Subject: WITHOUT PREJUDICE - P/97/20 PL & P/29/21/DOC Land at Summer Lane Pagham

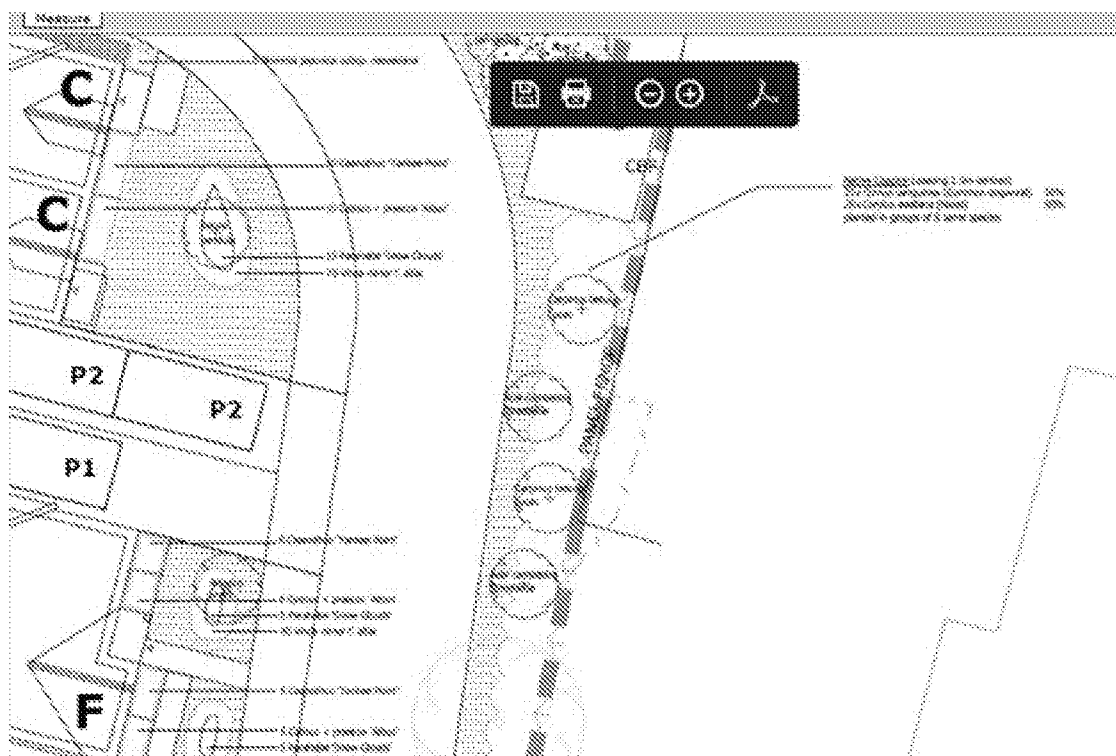
Therefore I thought that this would be a good moment to remind you of the solution to this mess suggested by my clients (The owner Occupiers of Meadow Sweet) as shown on the attached plan.

Site A - 46 Dwellings with vehicular access via adopted highway

Site B - Land set aside for SUDS to serve Spinnaker View, Mill Farm and Site A

Development of the site with 21 dwellings as currently proposed would require unlawful vehicular access via the public bridleway (shown yellow) and this is not owned by Drew Smith Homes or WSCC Highways in any case

Site C - Land approved as open space
